16 May 2022  
L 220516 NS RB Covering letter and Addendum Planning Statement FINAL

**Section 73 Town and Country Planning Act 1990**  
**Application to Vary Conditions 2 and 4 and Remove Condition 8 of Full Planning Permission Ref. 21/02366/F relating to land at Wincote, Cow Lane, Steeple Aston, OX25 4SG**  
**On behalf of Mr. Henry Squire**  
**Planning Portal Reference: PP-11254666**

## ADDENDUM PLANNING STATEMENT

Drawing Number	Revision
20064-SQP-ZZ-ZZ-DR-A-PL220	P3

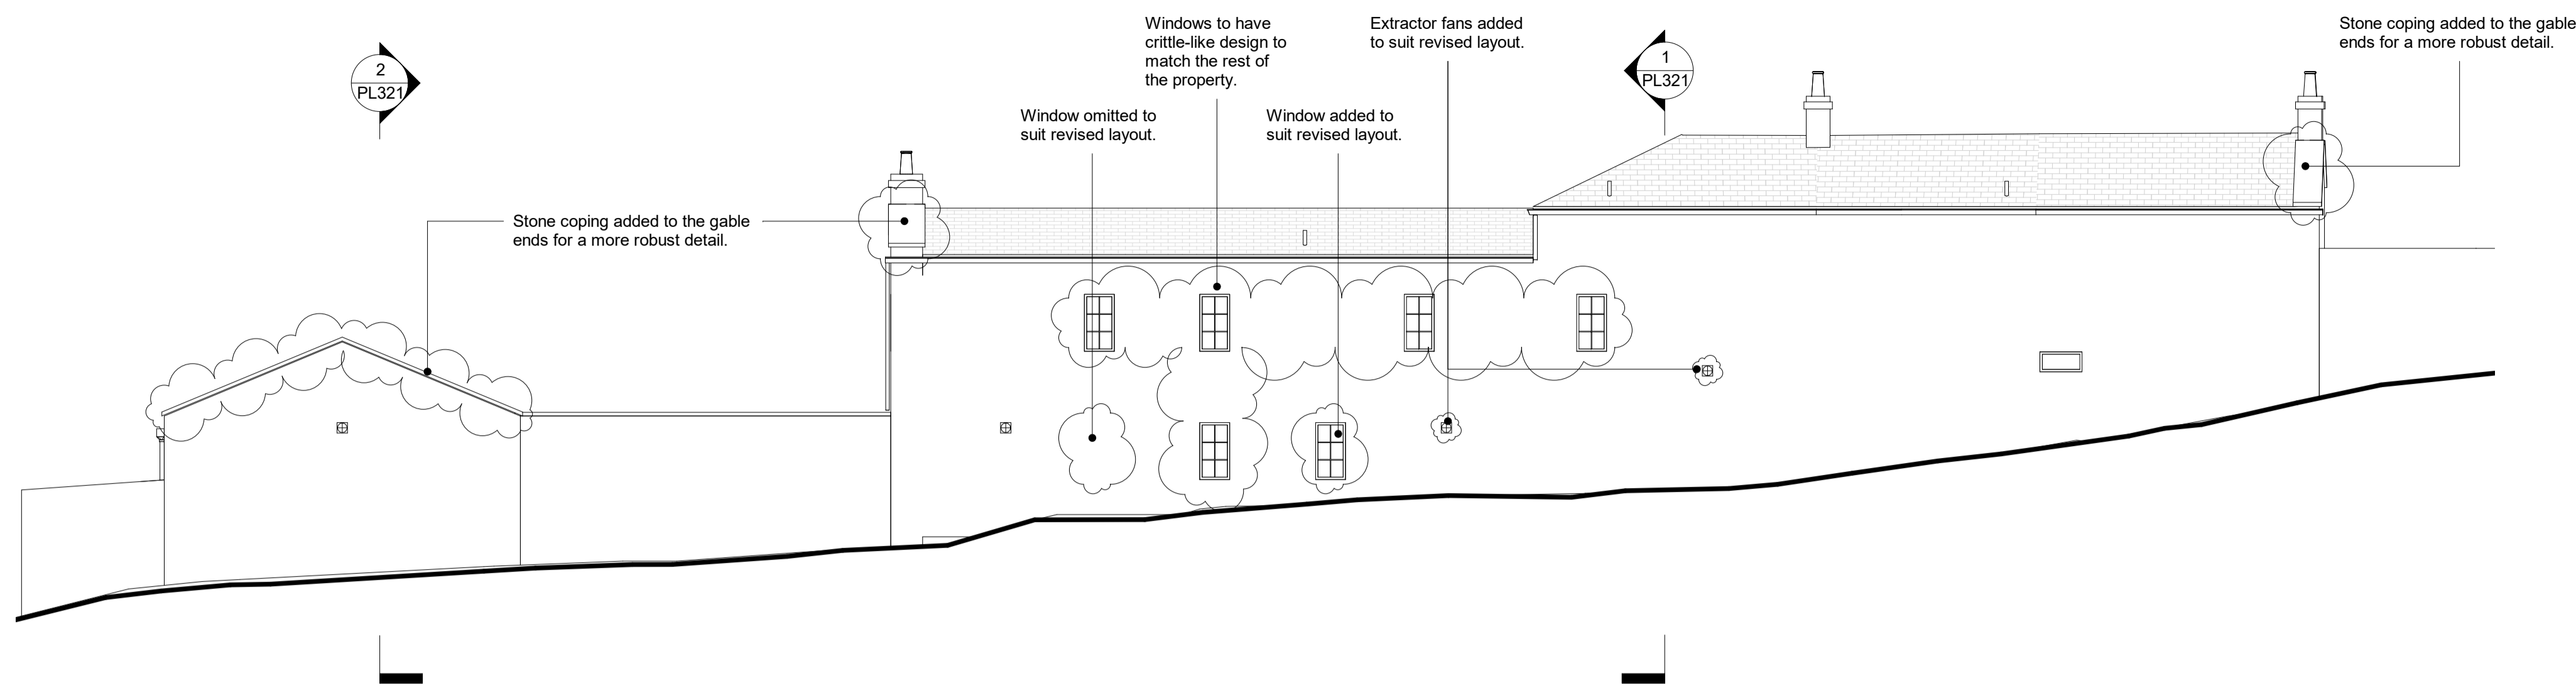
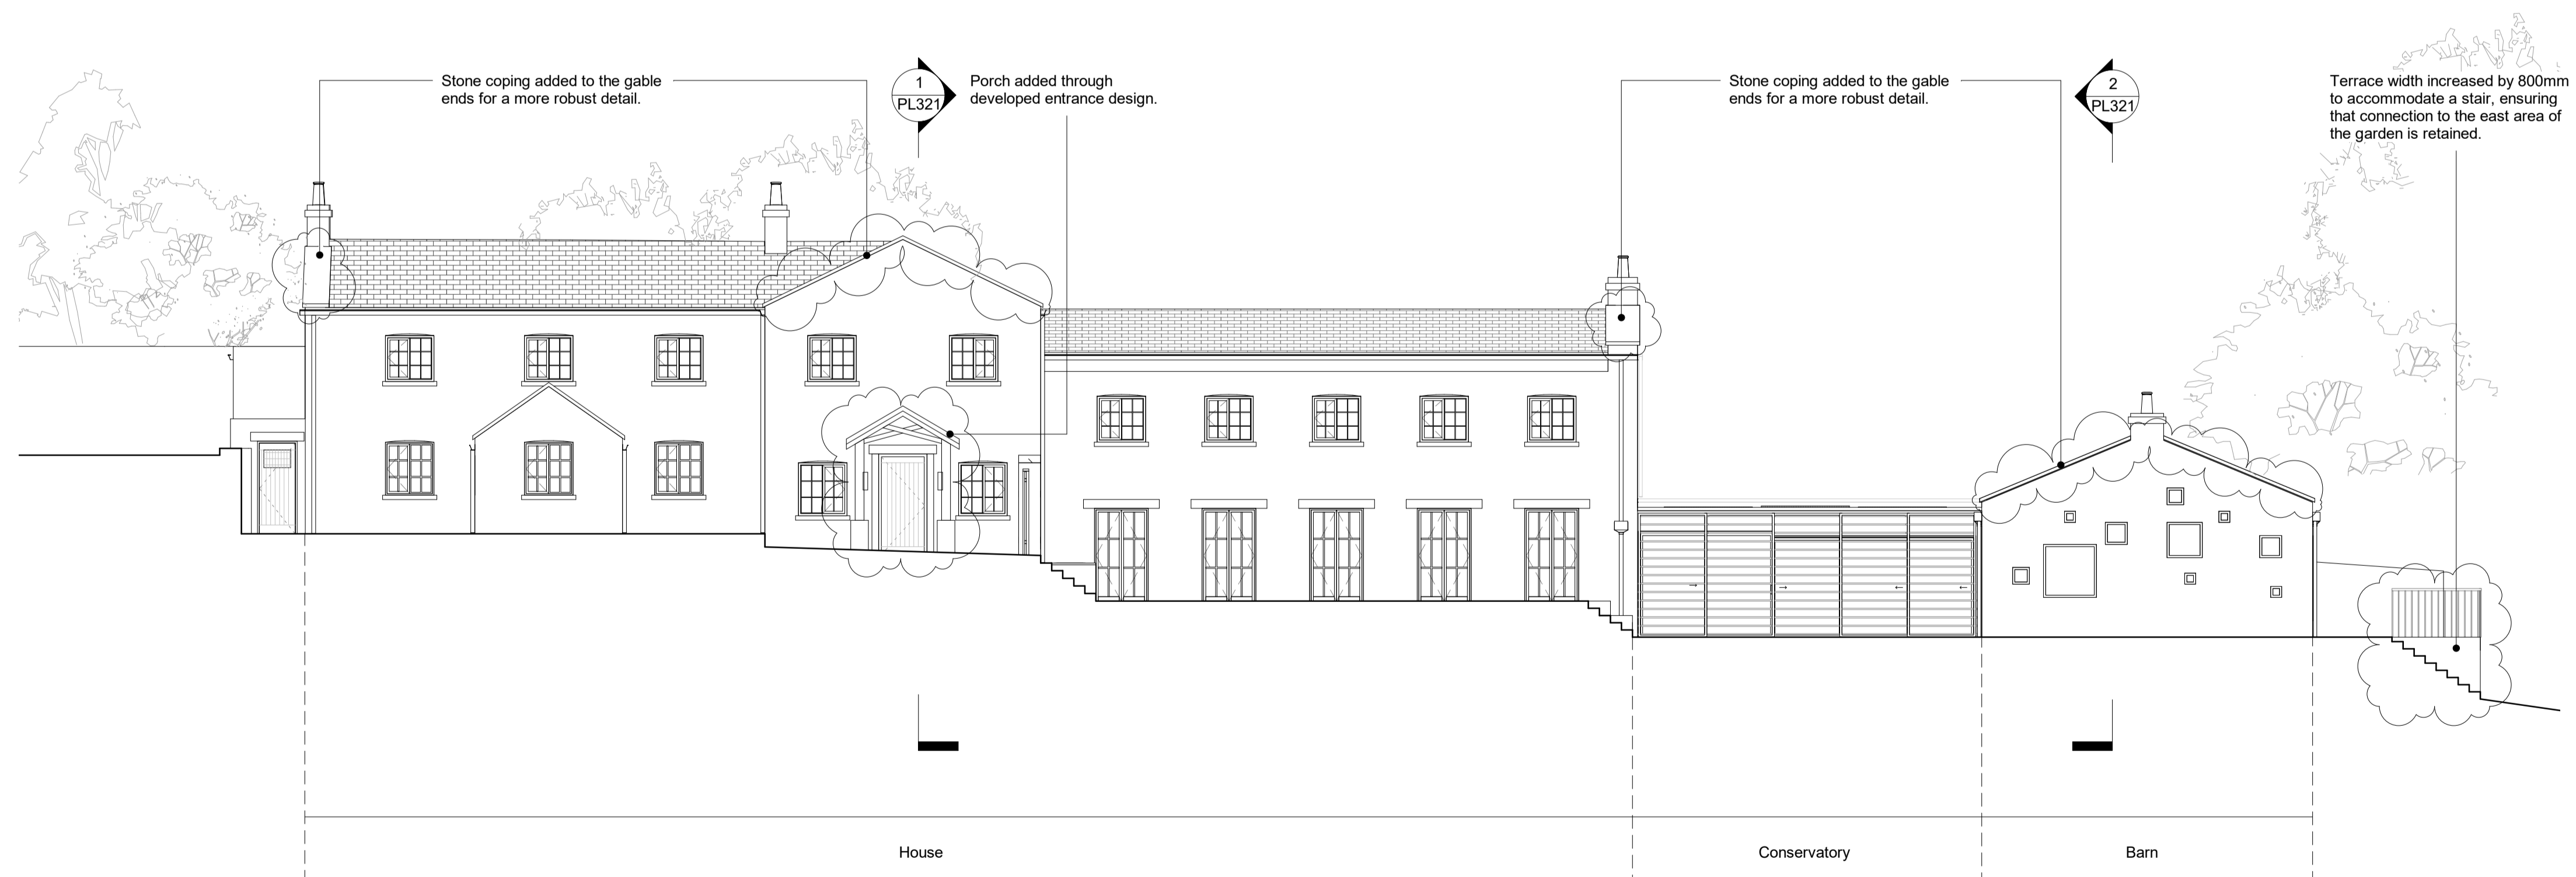
- Porch added to the entrance as part of design development.
- Stone copings added to the gable ends to create a more robust detail.

- Ground floor bathroom in the west wing has split into a shower room and en-suite for a more effective use of the space.
- Extractor fan added to the north façade of the utility room as required under the building regulations.

- Entrance hall WC moved to under the stairs to improve entrance accessibility and efficiency of the space.
- Window on north façade of snug has moved to suit the revised layout.

- Windows to the north and east facades to match style of the rest of the property.
- Bedroom windows above the entrance hall have been moved to sit centrally to the bedroom, windows at ground have also moved to maintain the alignment.

Drawing Number	Revision
20064-SQP-ZZ-ZZ-DR-A-PL321	P2

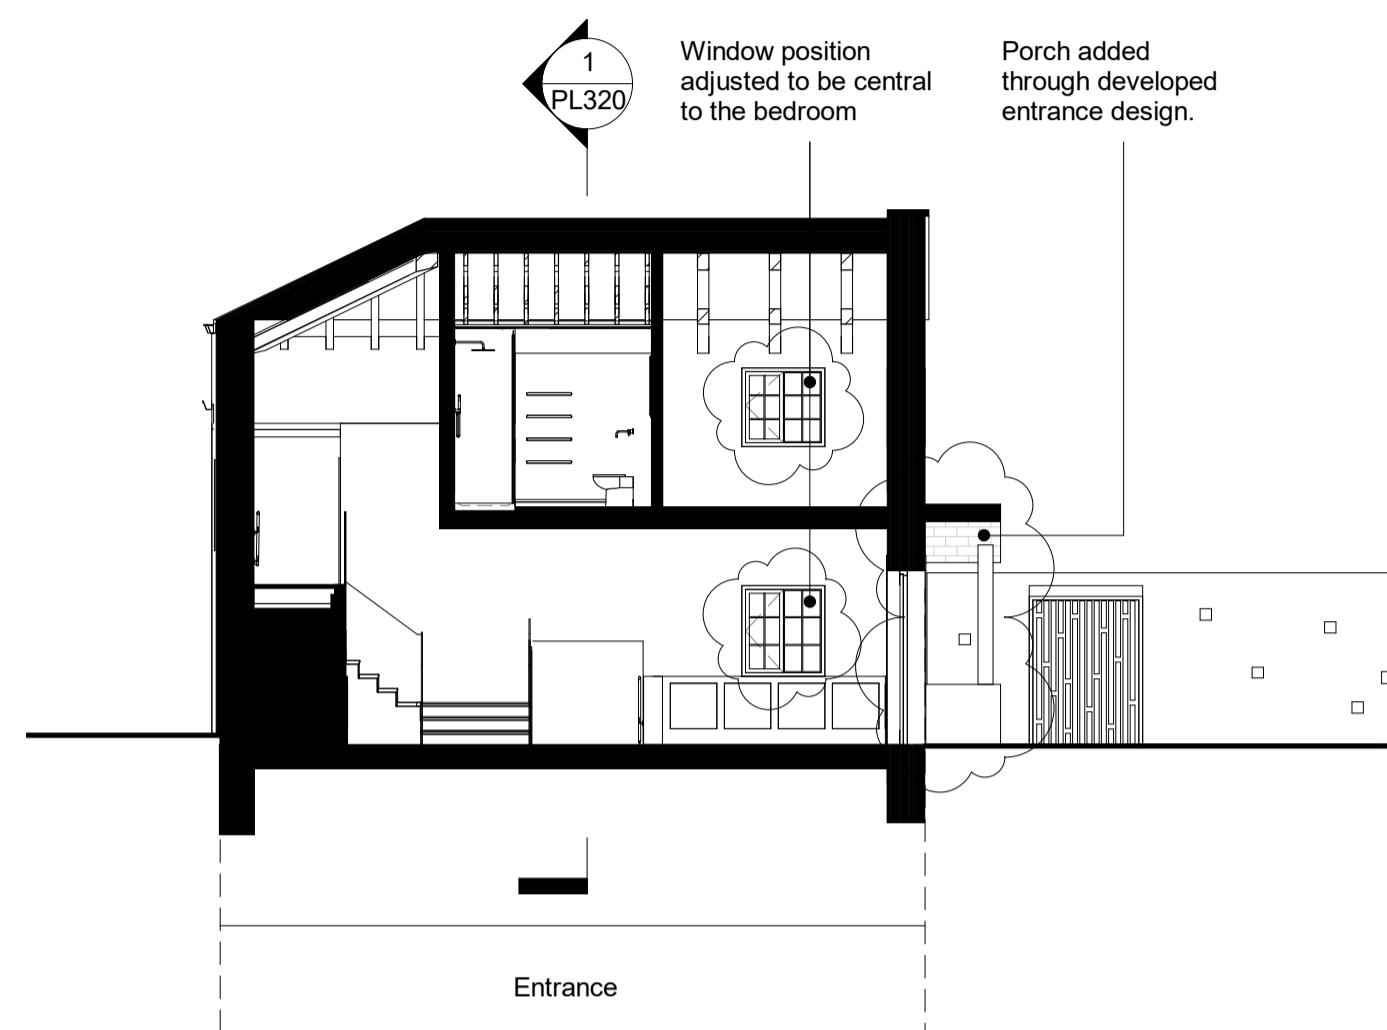
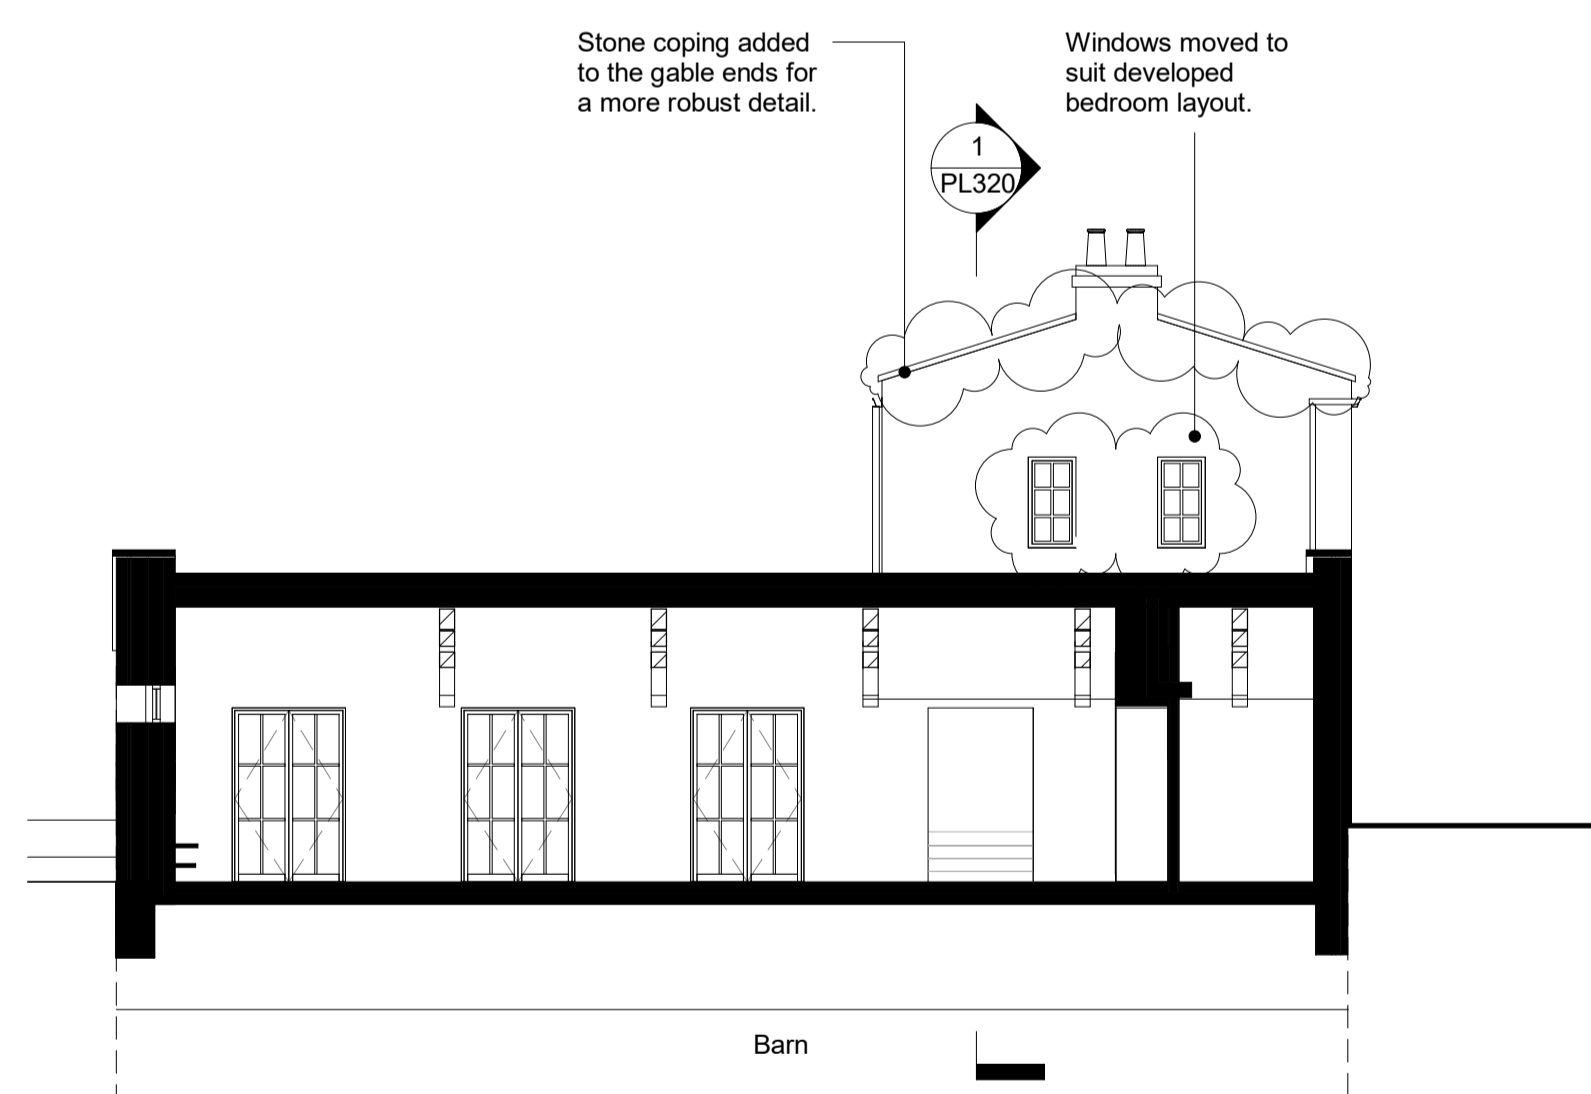
- Secret stair added for better connectivity between ground and first floor master bedroom.
- Hard landscaping increased to maintain the consented access widths around the barn.

- Barn increased in length by 1m to accommodate the detailed design of the fireplace and chimney without having a detrimental impact on the consented living spaces.

Drawing Number	Revision
20064-SQP-ZZ-ZZ-DR-A-PL320	P3

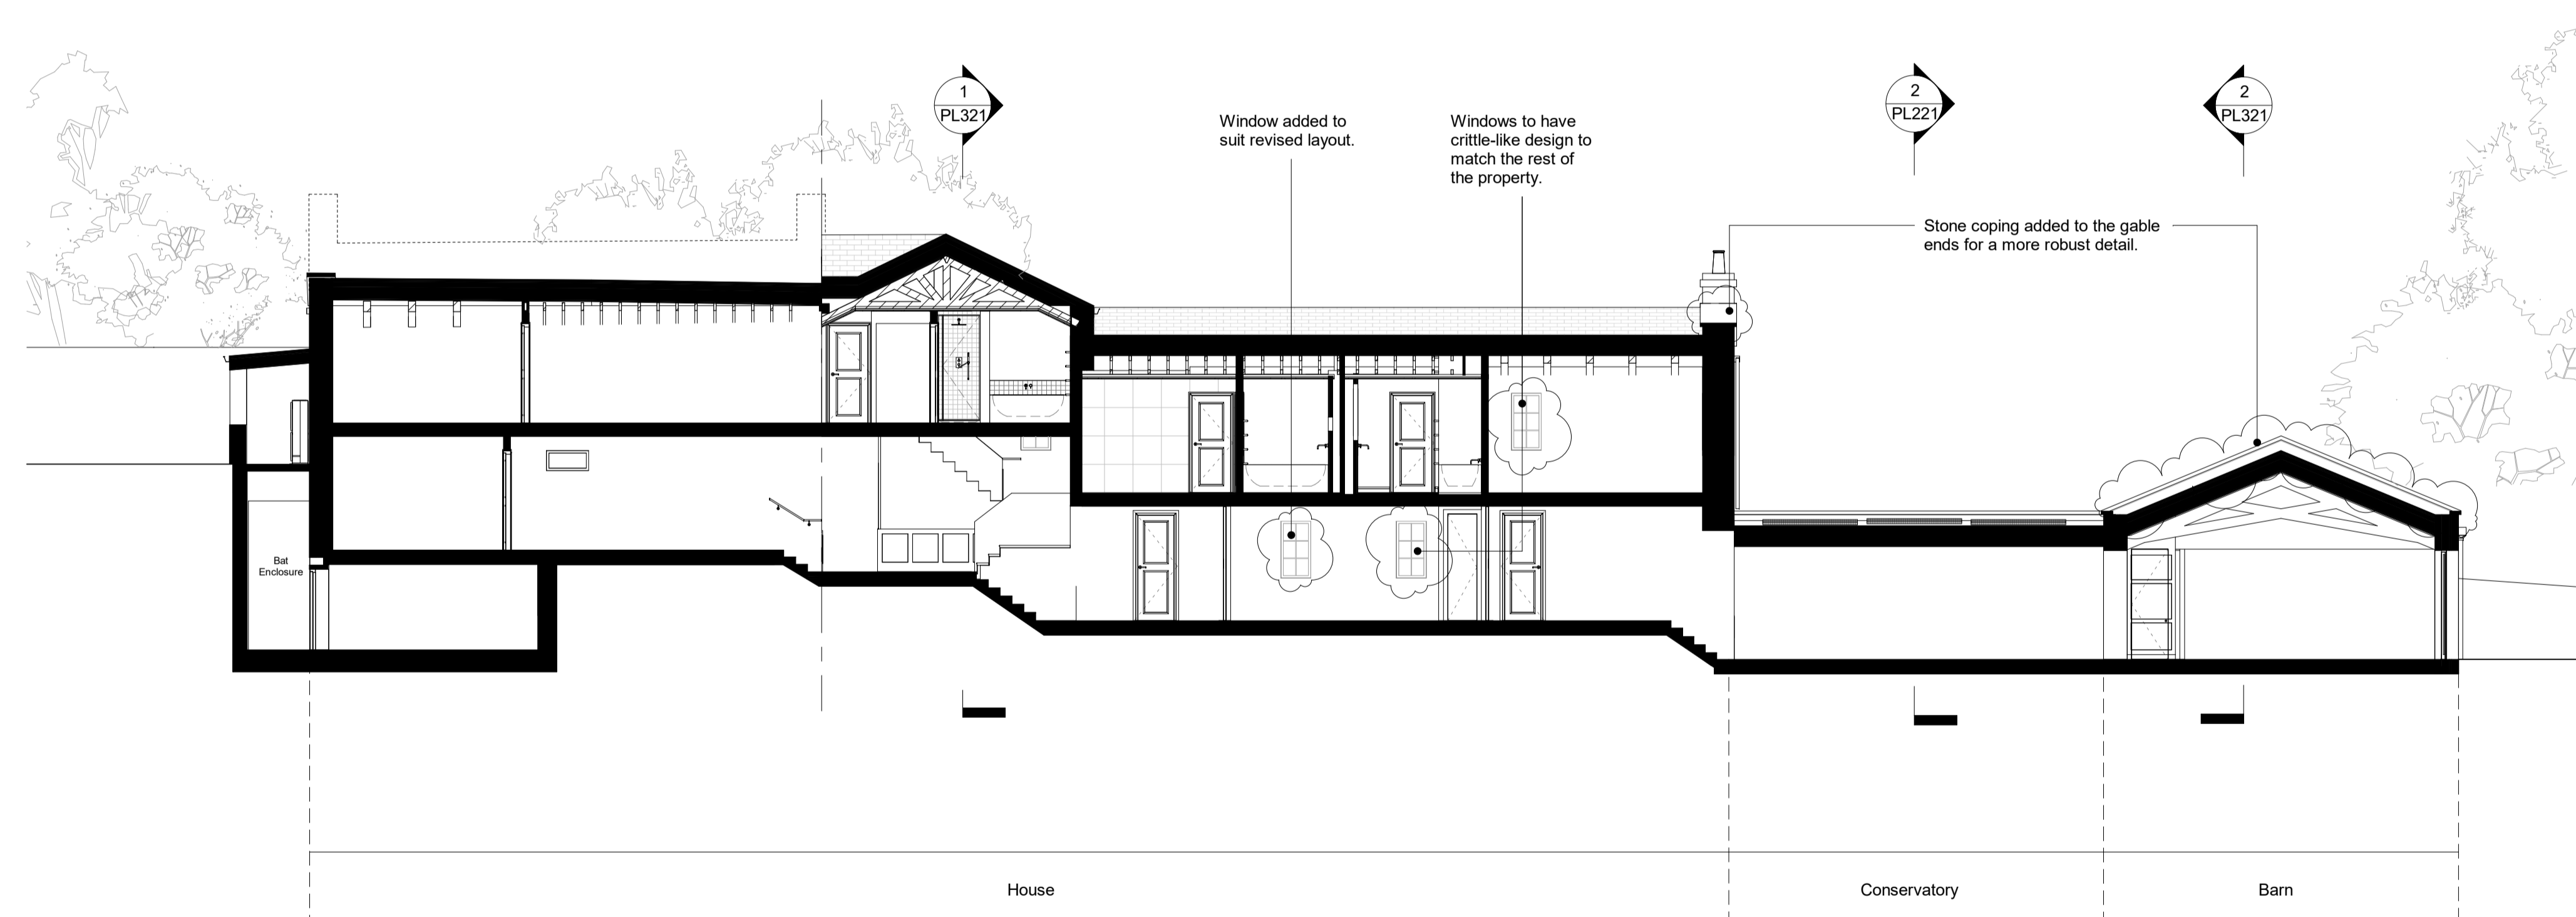
- Width of the barn terrace has increased by 800mm to accommodate a stair, ensuring that connection to the east area of the garden is retained.
- Layout of spaces along the east wing ground floor corridor have been revised to provide increased storage, better connectivity to the first floor master bedroom and a more usable living space.
